Responses to Comments

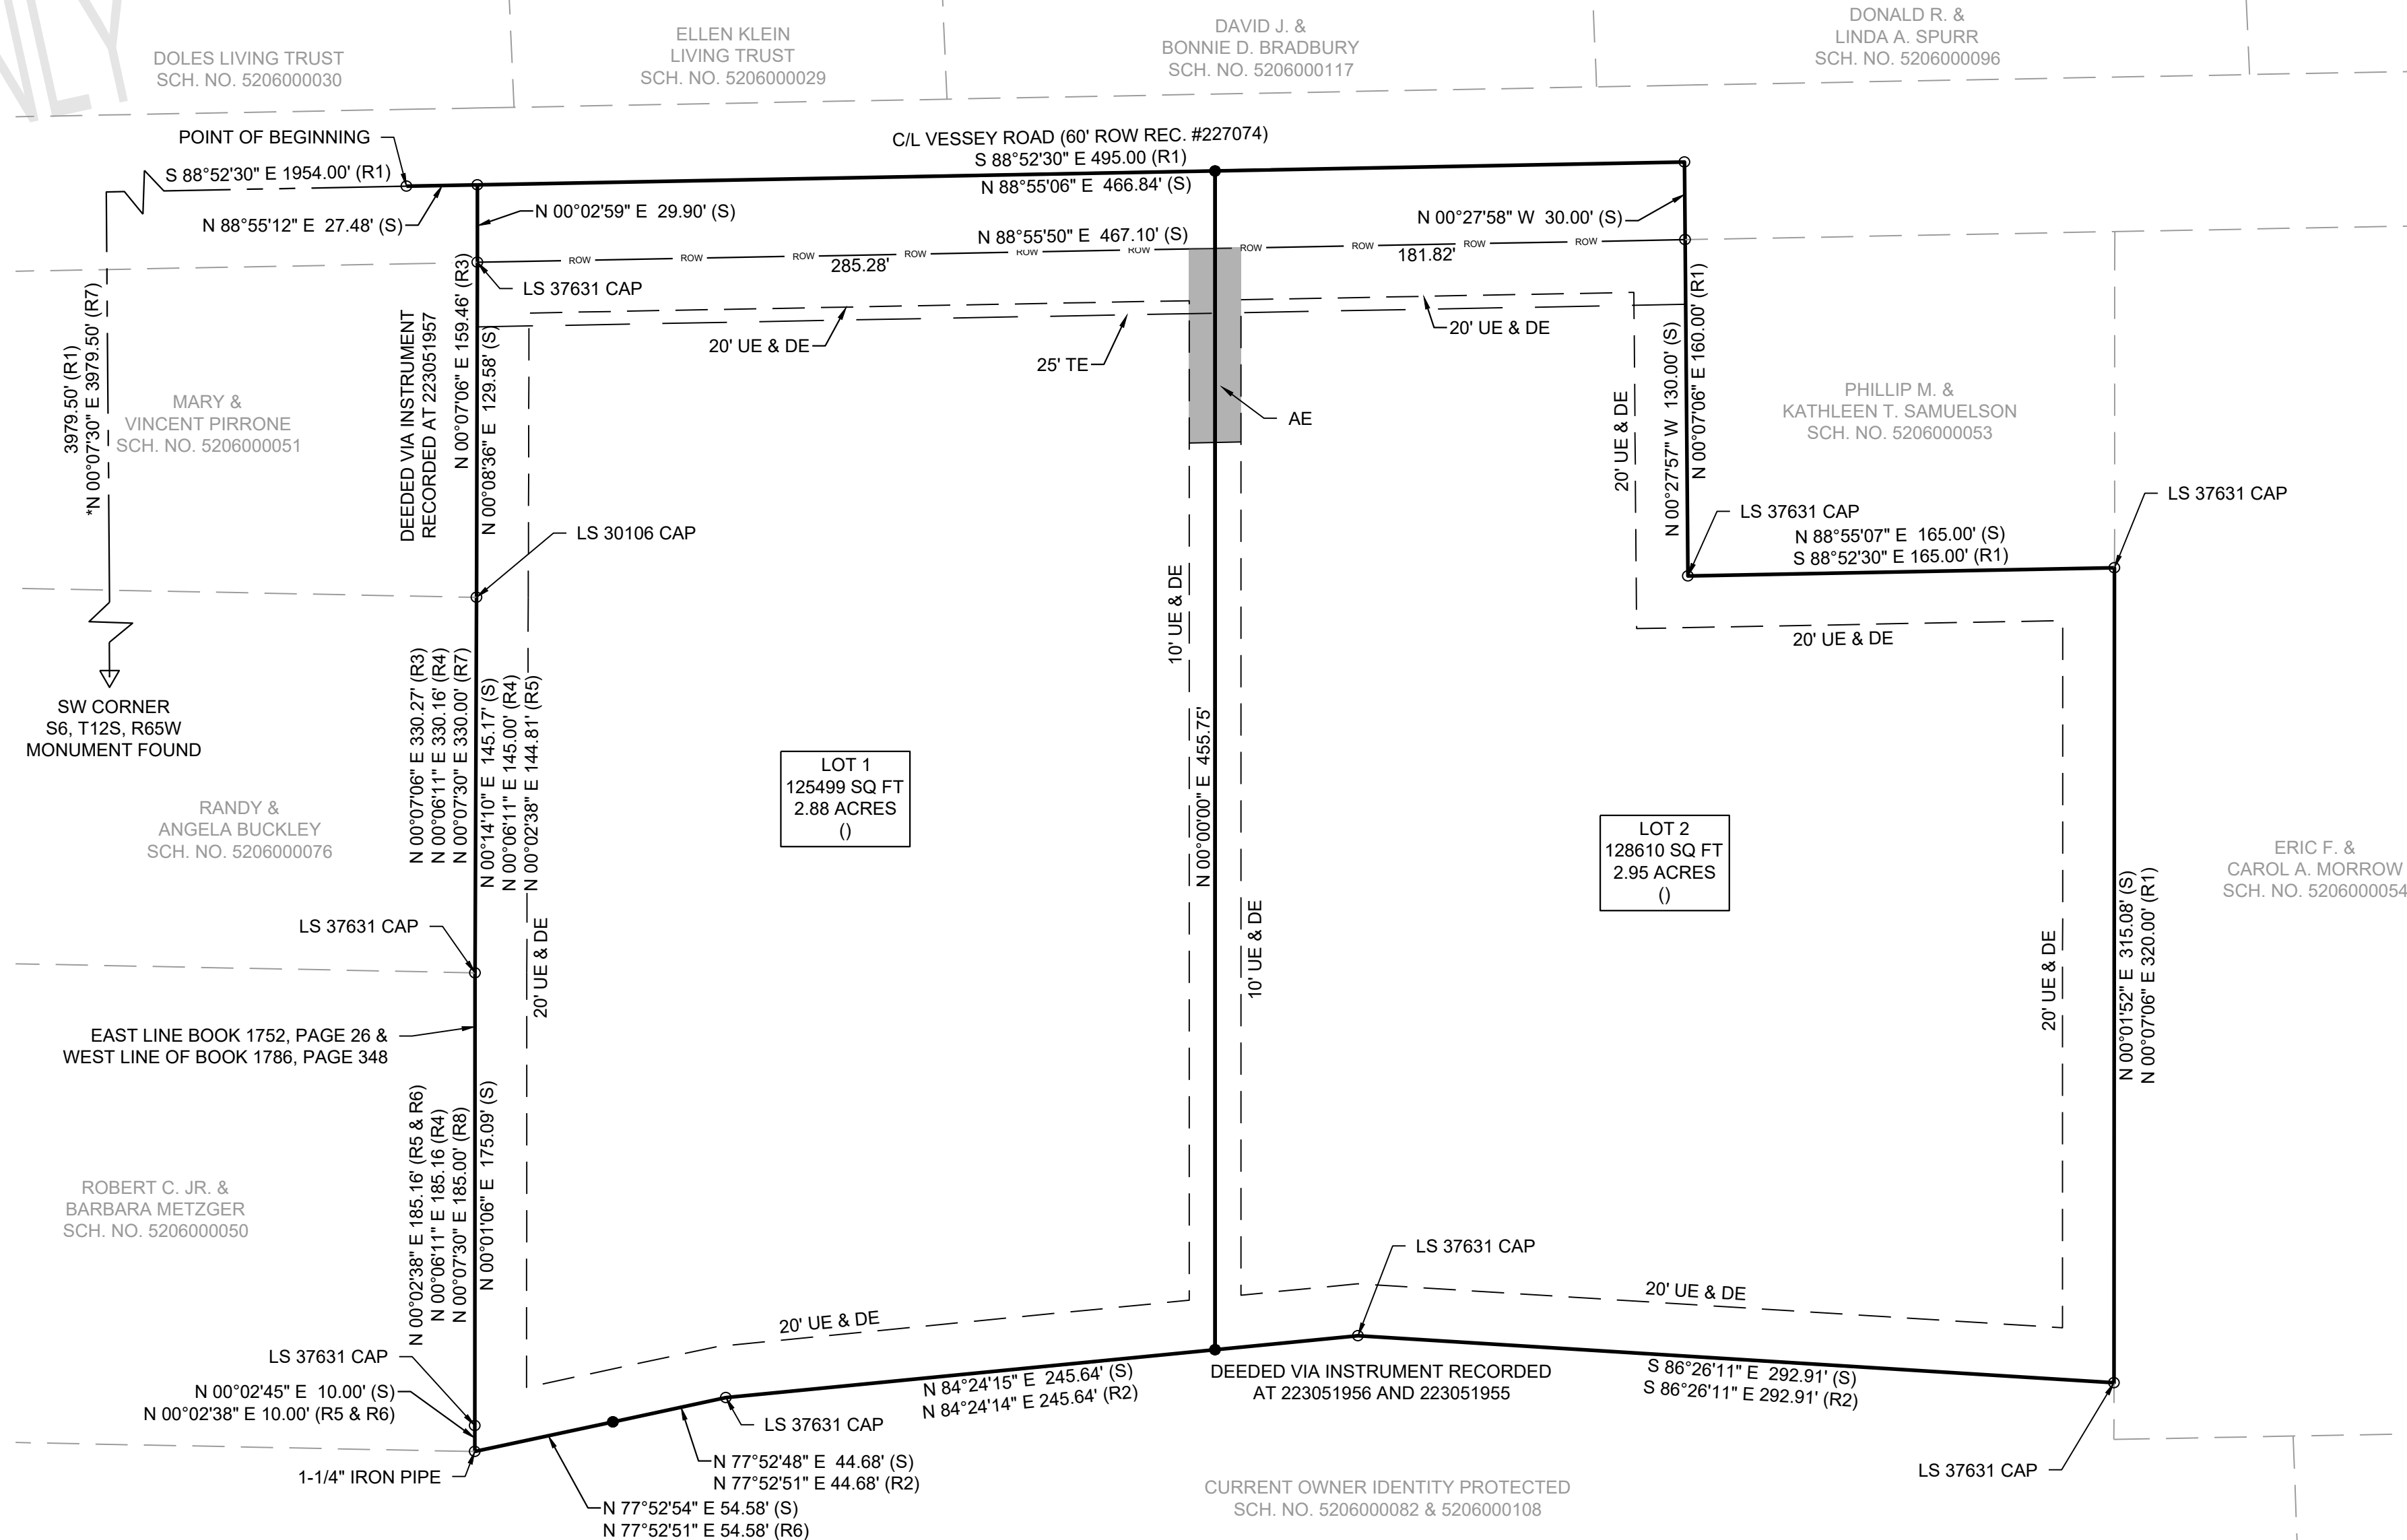
- Per BFFD a cistern is required and per the LDC a cistern easement is required, please show the cistern easement.

- As indicated in the early assistance meeting, Vessey Road is a collector per the MTCP with an 80' ROW. Request that additional 10' of ROW be provided so that there is a total of 40' from the centerline.

Fire fighting water supply demands and cistern sizing are dependent upon occupancy hazard, type of construction, structure dimensions, and exposures. Since the developer is not building the houses, this required information is unknown at this time. It is also unknown whether there will need to be a separate cistern for each lot or one that can be shared between the two lots. The locations of the future homes within the lots are also unknown, so placing the cistern to meet all distance requirements isn't possible at this time. Thus, it is the future homeowner(s) responsibility to determine the cistern requirements, location, etc. at time of building permit application. Once this information is determined by the future homeowner(s), the cistern can be located on the site and an easement for the cistern can be dedicated via separate instrument.

Additional ROW has been added to the plat

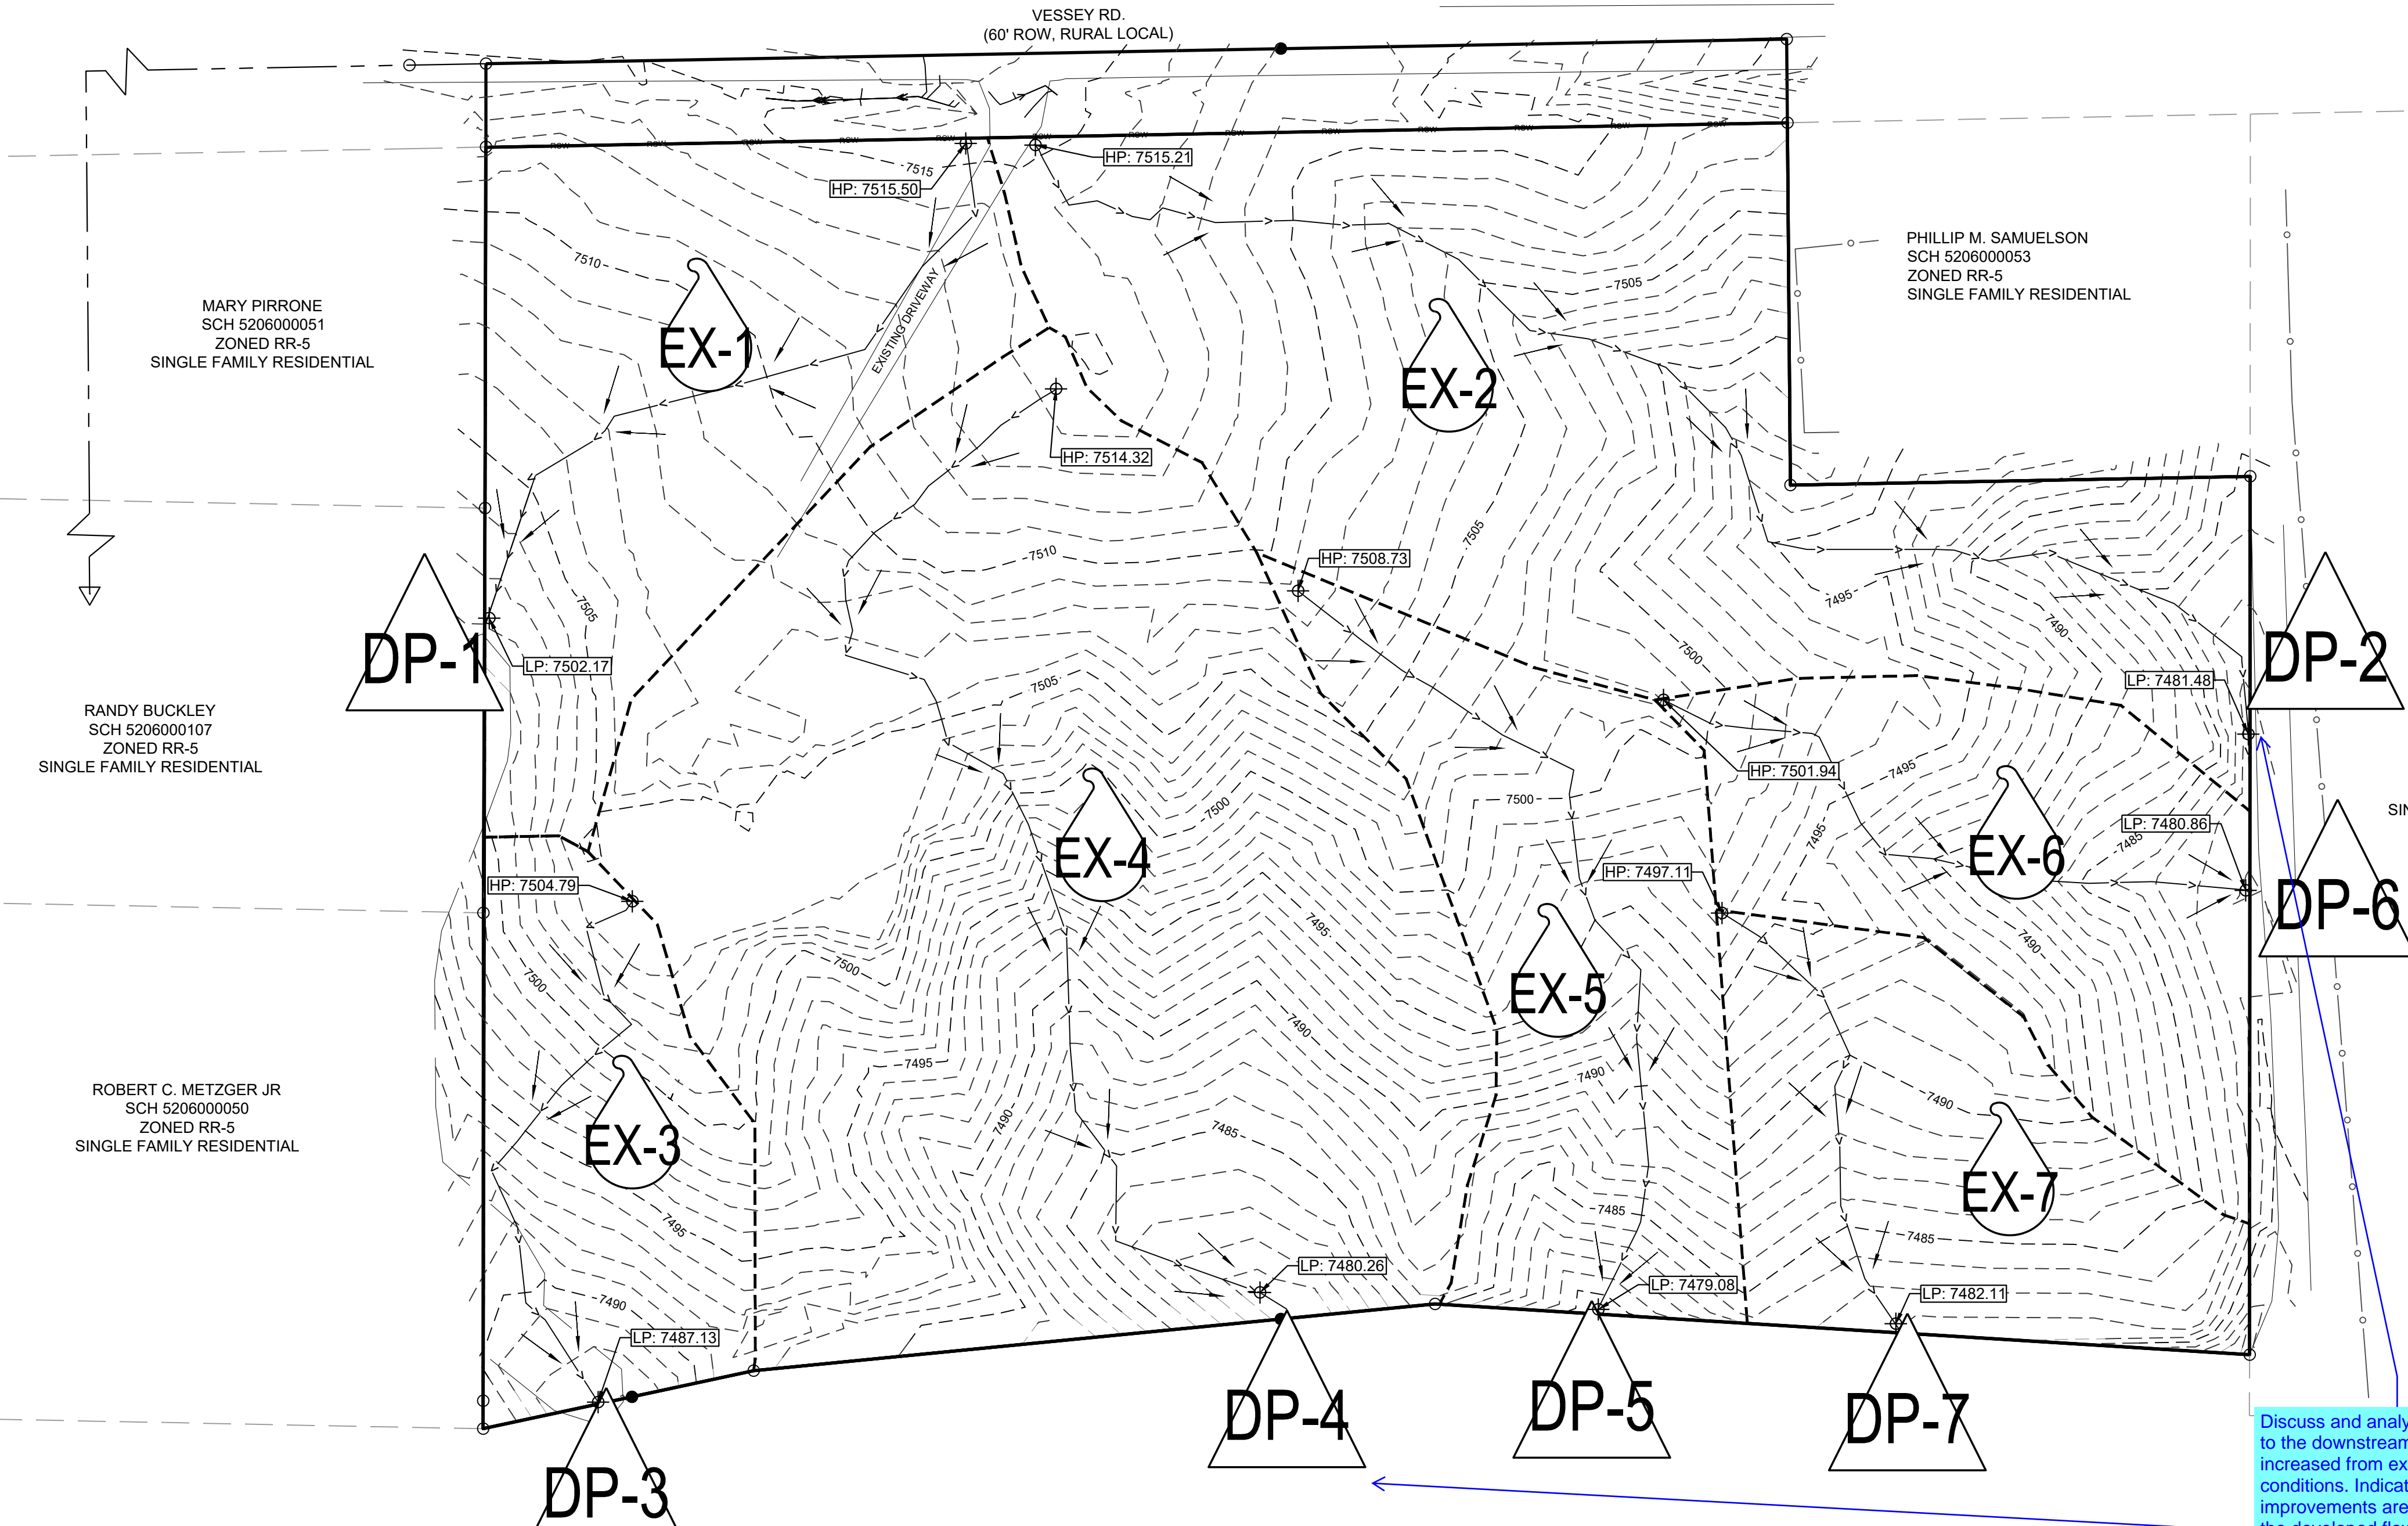
- Discuss and analyze the impacts to the downstream as flows have increased from existing conditions. Indicate if improvements are needed due to the developed flows. A suitable outfall is needed (ECM 3.2.4).

- Please label proposed driveway

- Please show and label existing and proposed contours in the legend.

Runoff calculations have been revised and downstream effects have been addressed.

Done

Done
